Erection of a single storey outbuilding to be used as a washroom/garden studio
7 Sea Way Middleton-On-Sea

Representations of Middleton on Sea Association in respect of Planning Application M/73/19/HH - 7 Sea Way, Middleton on Sea.

Garden studio & washroom

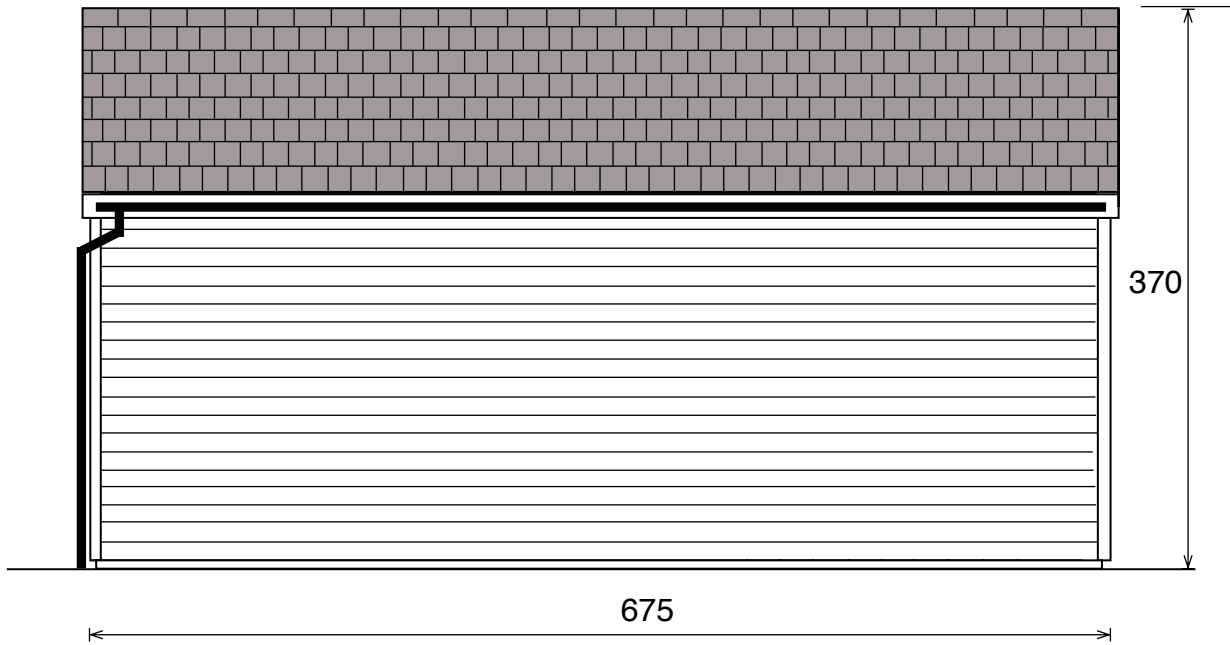
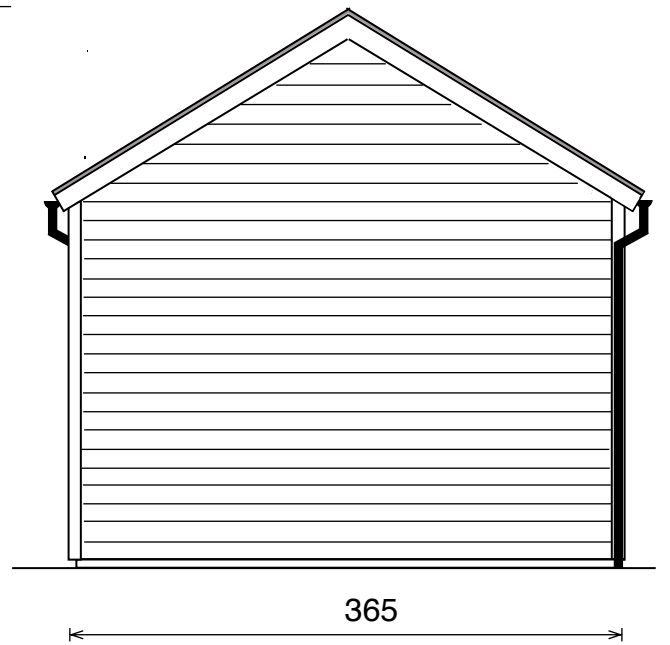
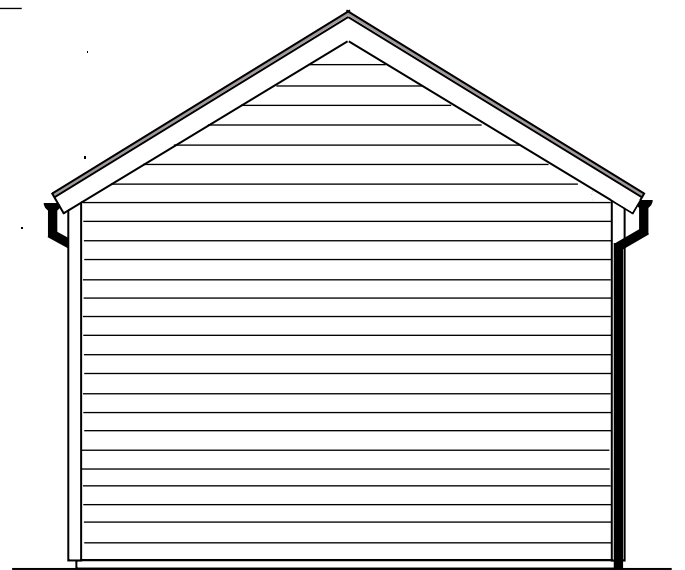
Middleton on Sea Association object to the erection of the proposed outbuilding which in scale, mass and location, 0.5m from the road frontage with Sea Way would introduce an unacceptable precedent within the Middleton on Sea Area of Character. Its ridge height of 3.7m would project significantly above the boundary enclosure and together with the proposed steel profiled roof would impact detrimentally on the street scene in conflict with the design principles of the Arun Local Plan and the philosophy of the Village Design Guide (which is a material consideration in the context of the Arun District Local Plan).
